DECISION DELEGATED TO HEAD OF PLANNING

Application No: H12-0290-25 **Applicant:** Mr & Mrs R Phillips
Proposal: Proposed first floor extension forming bedroom / en suite / ironing room, alterations to lower roof and changes to ground floor windows
Location: 30 Marriots Gate Lutton Spalding
Terminal Date: 16th May 2025

Dwg No: A1. PROPOSED
ELEVATIONS
Scale: 1:100

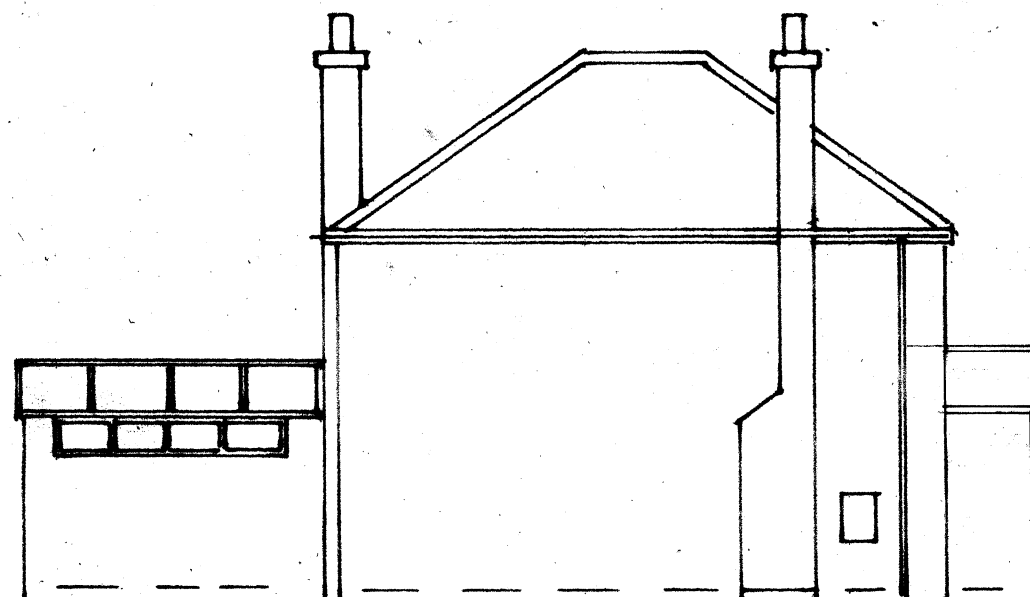
The dwelling currently features a single storey side extension with a gable end roof form, measuring 4.4m in height from the ground level up to the ridgeline. The eaves measure 2m in height. The proposals seek to extend above this existing extension. The ground floor footprint of the dwelling would therefore remain the same. The proposed ridgeline would measure 7.1m in height from the ground level. This is slightly below the ridgeline of the main dwelling.

Two evenly spaced windows are proposed at the ground floor level on the front of the extension, and two dormer windows are proposed above. The symmetrical positioning of the windows is acceptable. Similar windows are proposed on the rear of the extension, however, these windows would not be visible from the street scene. There are currently two windows on the side elevation and a door at the ground floor level, and these would remain unchanged. An additional window is proposed on the side elevation at the first-floor level. The submitted plans indicate that this would be obscure glazed.

The nearest dwelling to the proposed extension is 28 Marriots Gate, which is located to the south of the site. A window is proposed on the side elevation of the extension at the first-floor level. According to the proposed elevations plan, the window is proposed to be obscure glazed. As such, this should reduce the degree of overlooking with 28 Marriots Gate to the south. It is considered appropriate to secure the use of obscure glazing for this window through a condition for clarity.
